National Infrastructure Planning
Temple Quay House
2 The Square
Bristol, BS1 6PN

Our Ref: EN010084

Application by Vattenfall Wind Power Limited for an Order Granting Development Consent for the Thanet Extension Offshore Wind Farm

Advice following issue of decision to accept the application for examination

## Key Plan (Onshore)

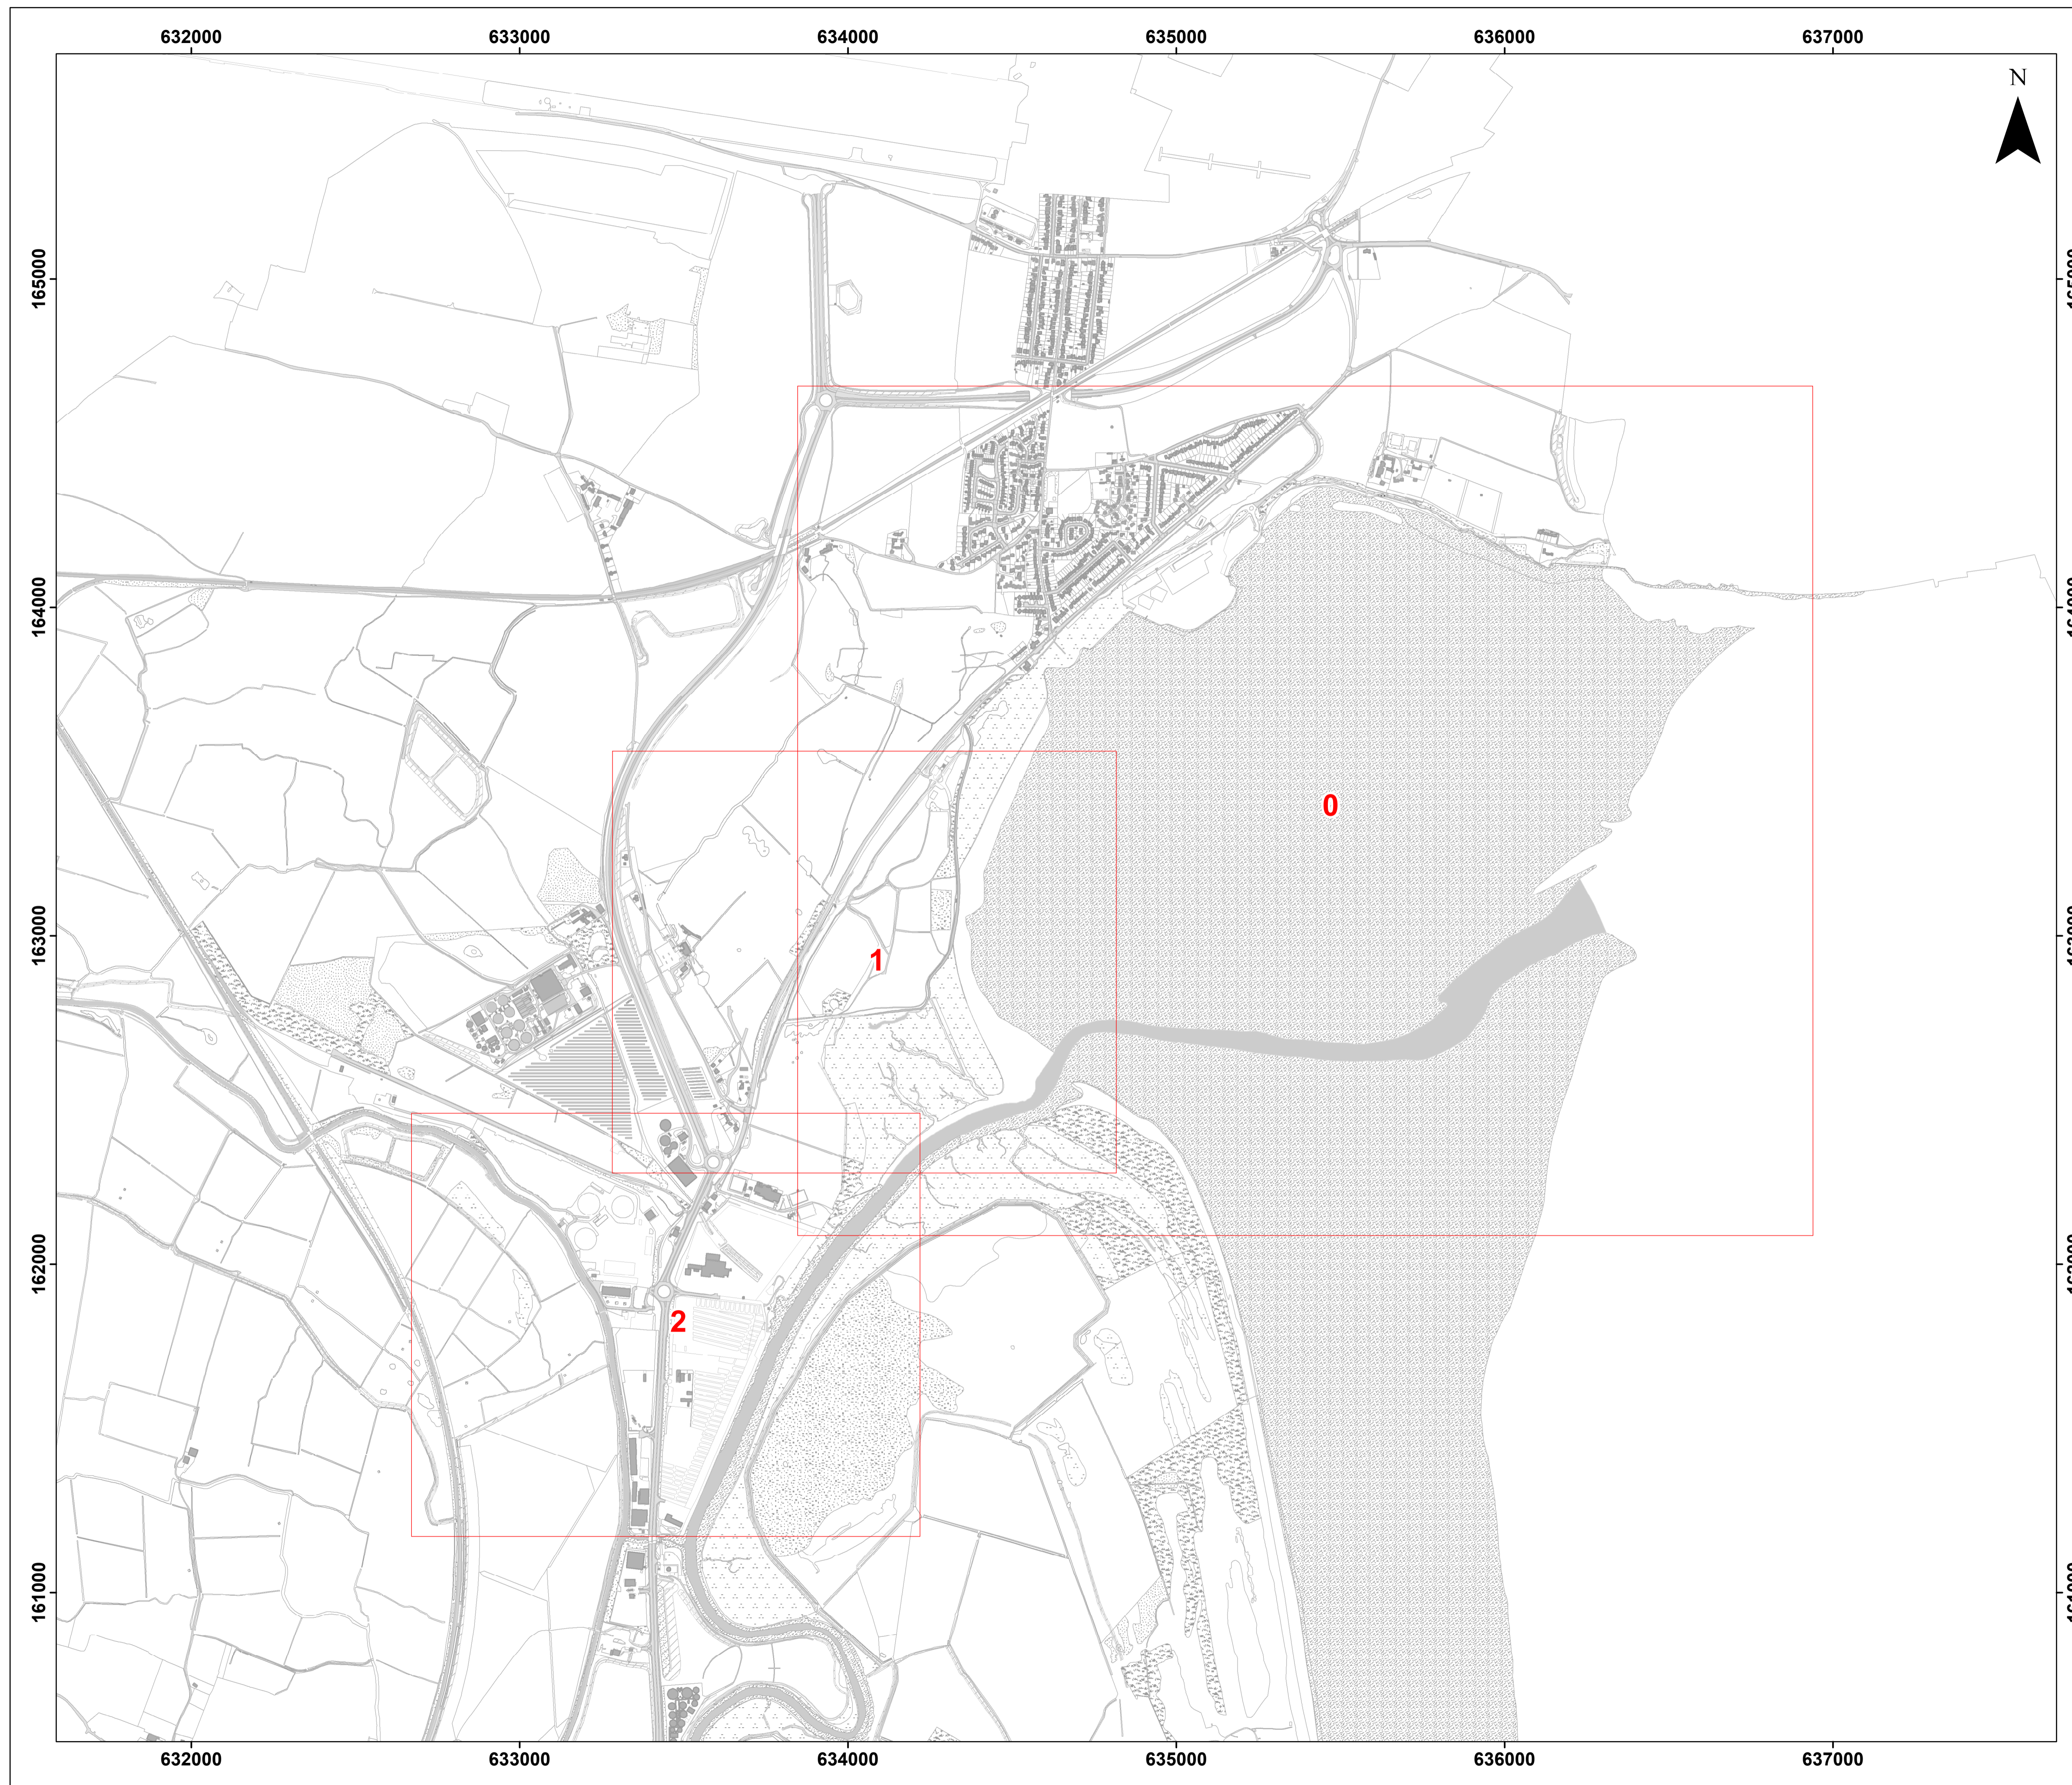
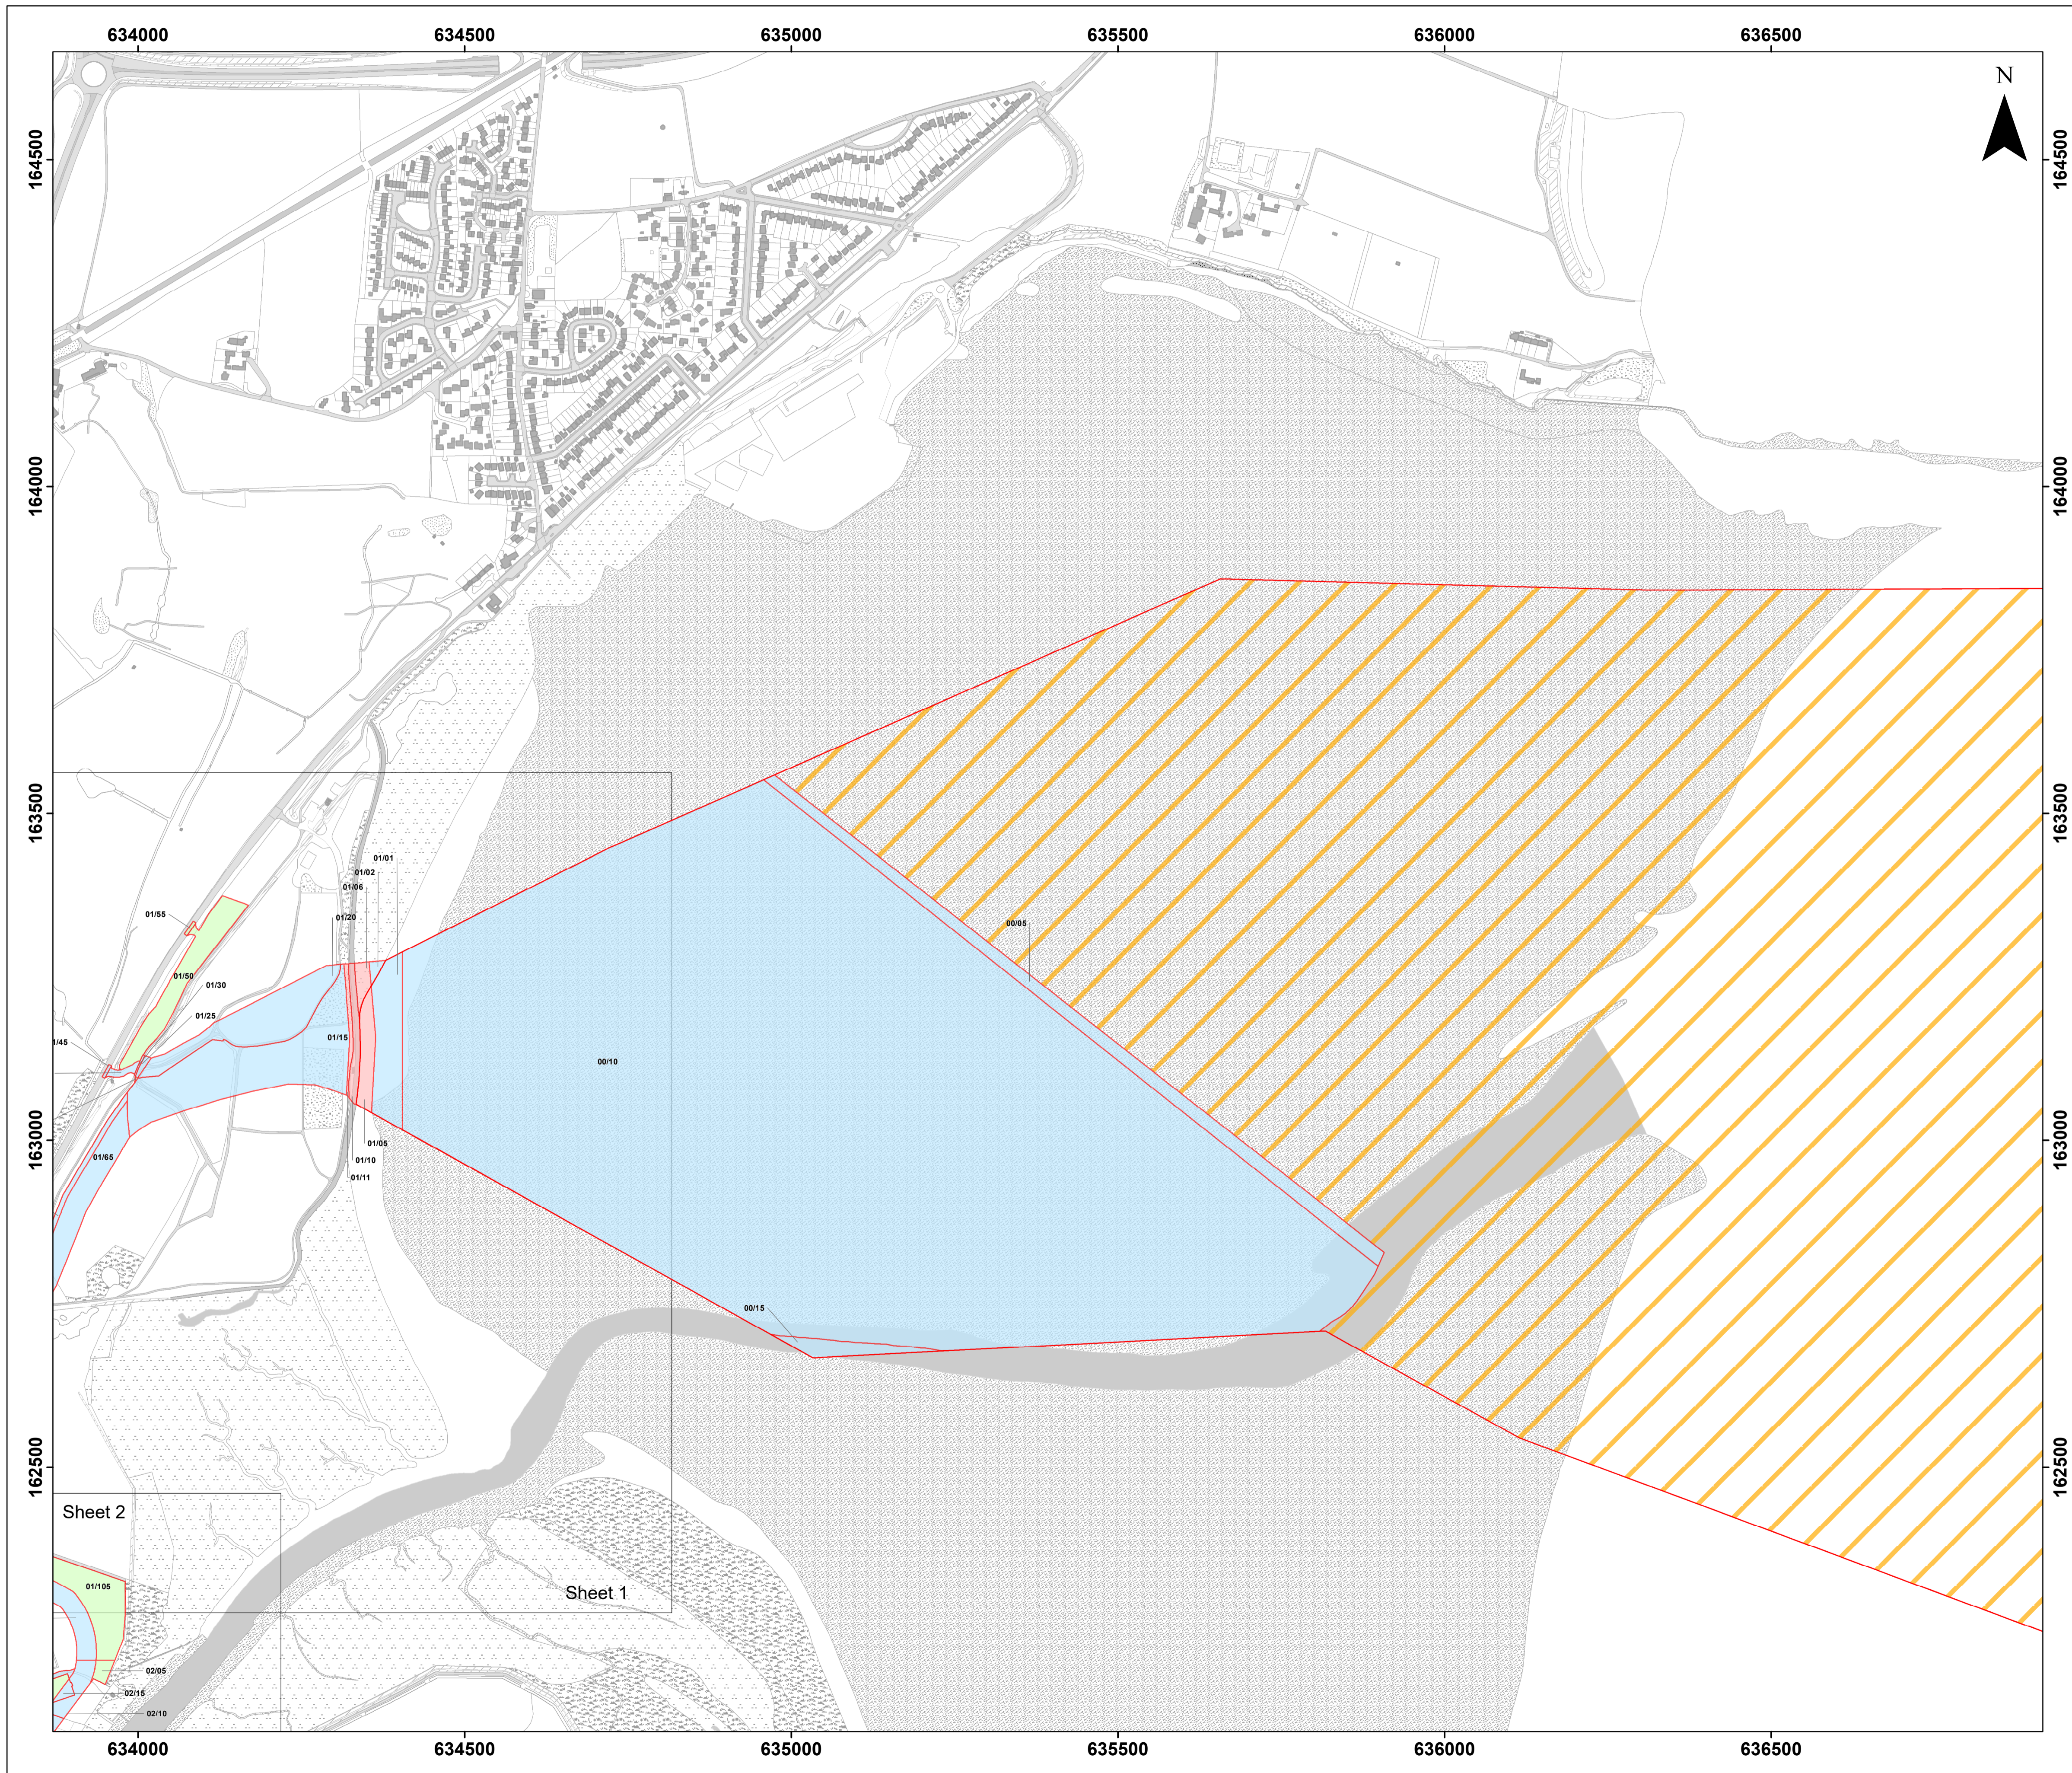
Please provide updated Land Plans that can be read which include:

- All relevant landmarks as described in Column 2 ('Description of Land') of the BoR e.g. Pegwell Bay Country Park, Sandwich Road, Ebbsfleet Roundabout and the A256 to be reflected on the relevant Sheets associated to the Land Plans.
- Insets to assist the reader.
- All plots on the individual sheets to be provided with the correct plot reference and colour code which is consistent with the other application documents.
